From: Stanley James [REDACTED]
Sent: 13 May 2022 21:35
To: Kathryn Welch <Kathryn.Welch@arun.gov.uk>
Subject: 10, Fosters Close.

Re: R/90/22/HH 10, Fosters Close.

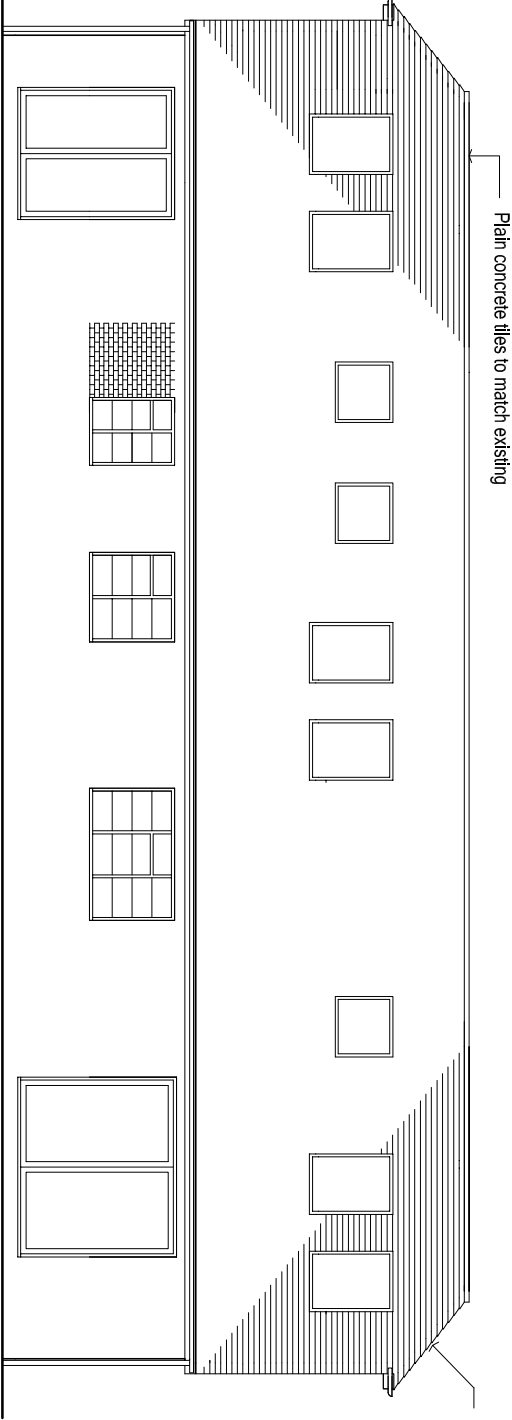
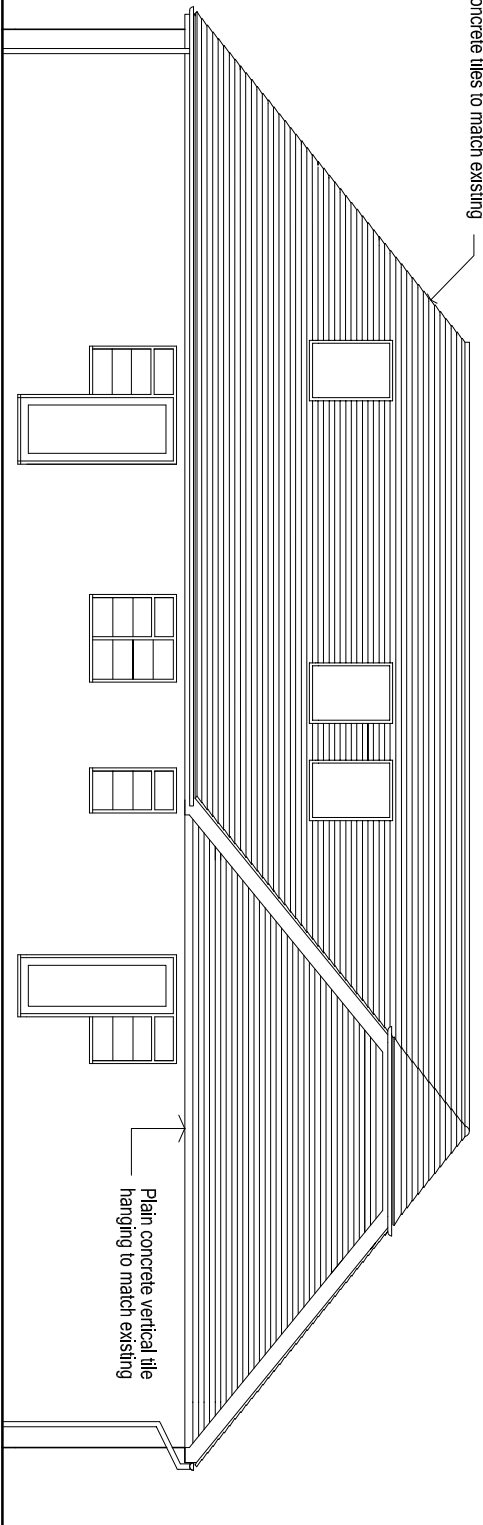
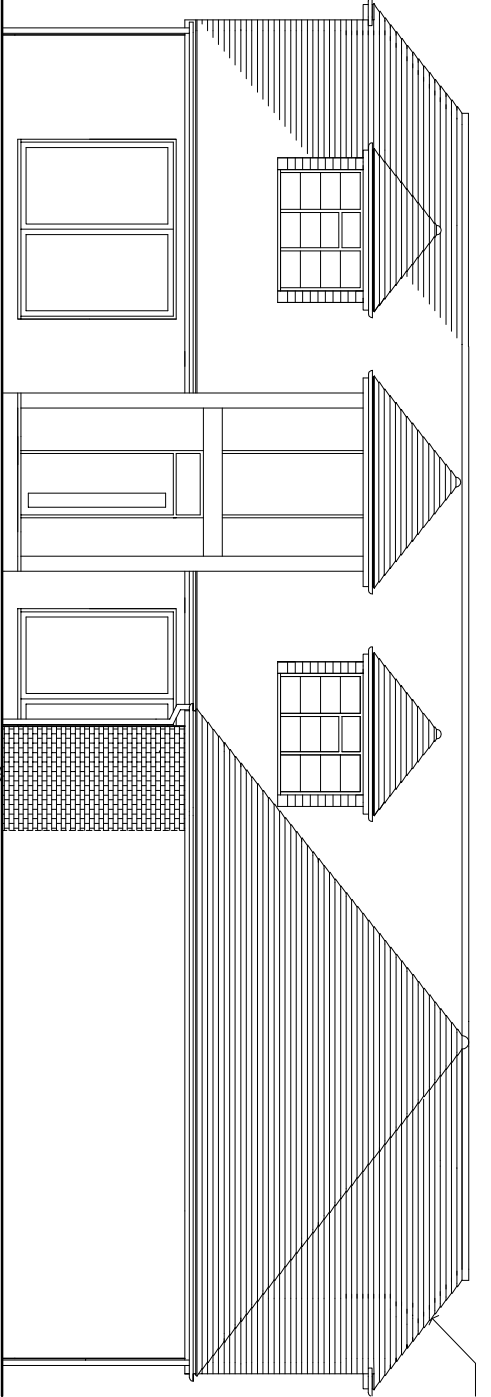
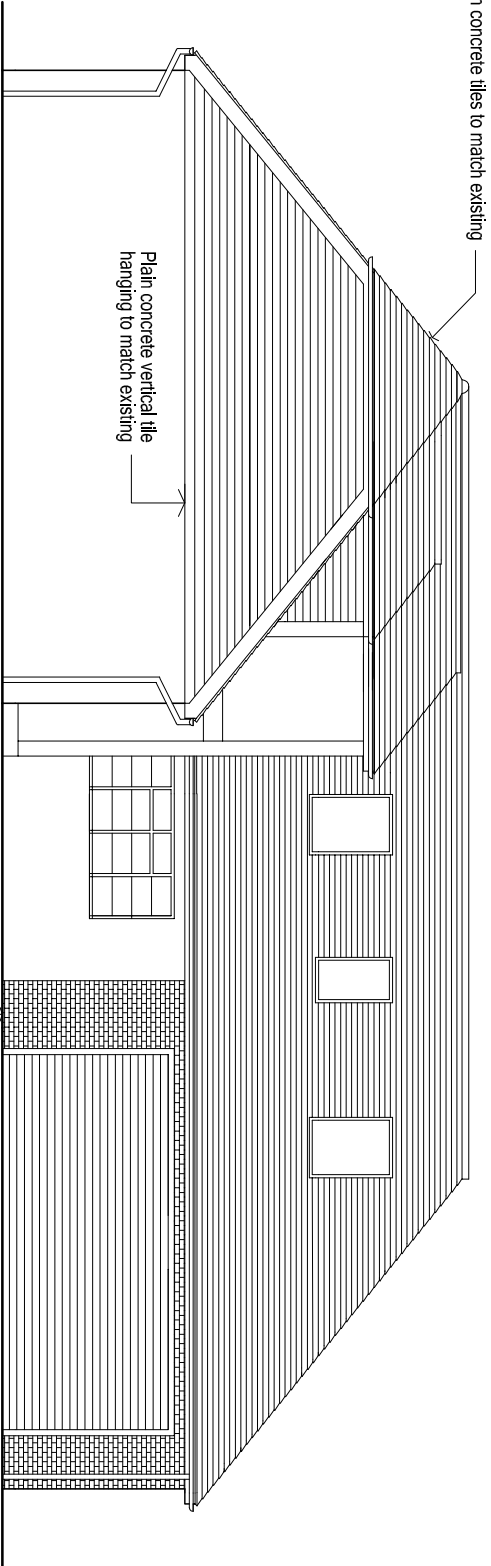
I am a keen gardener and the part shown has only just been re-landscaped with a seating area which will now be completely overlooked by the Velux windows of No. 10. The violation of my privacy is deeply upsetting. I am now

DRAWING TITLE:
PROPOSED FIRST FLOOR PLAN
PROJECT:
LOFT CONVERSION WITH HIPPED TO GABLE ENDS, DORMERS TO FRONT ELEVATION & GARAGE
EXTENSION WITH RAISED RIDGE

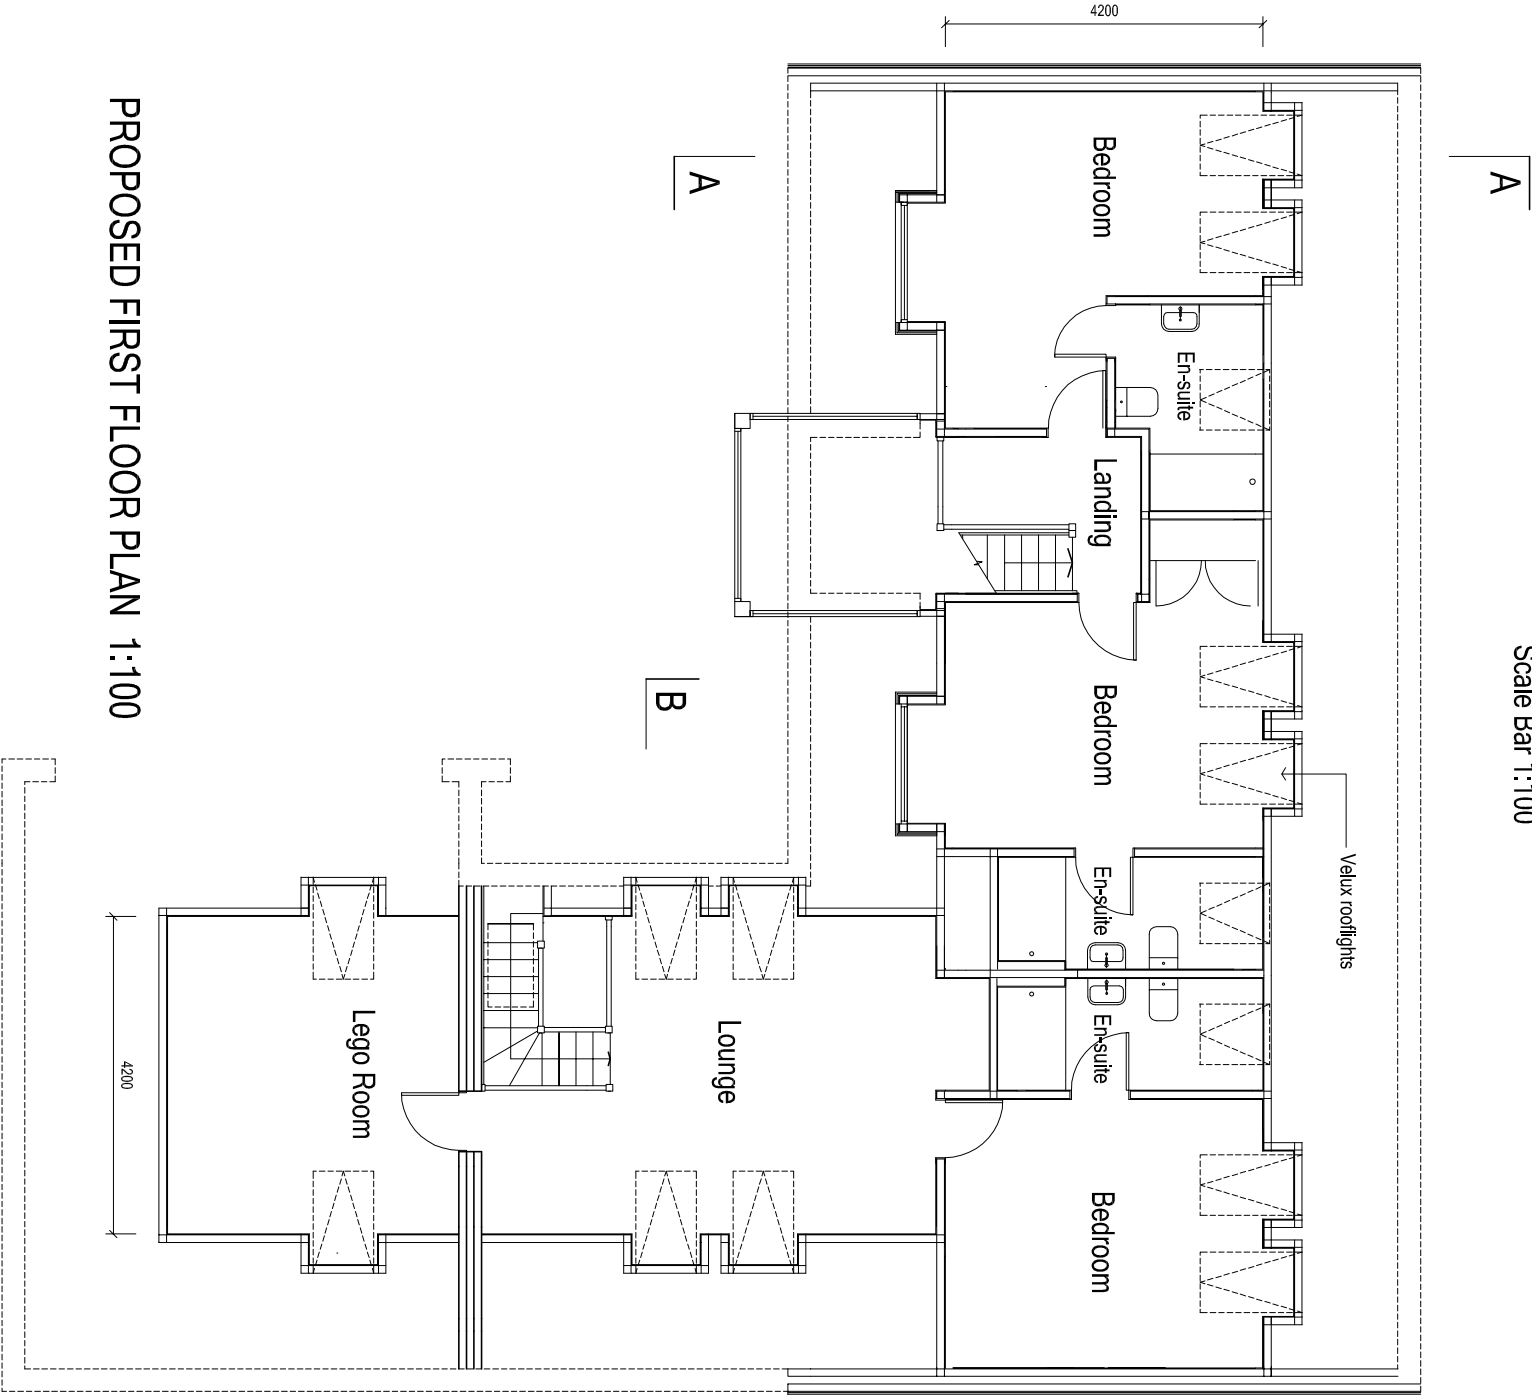
On the first floor of the plans is a "Lego" room. What actually is a Lego room?
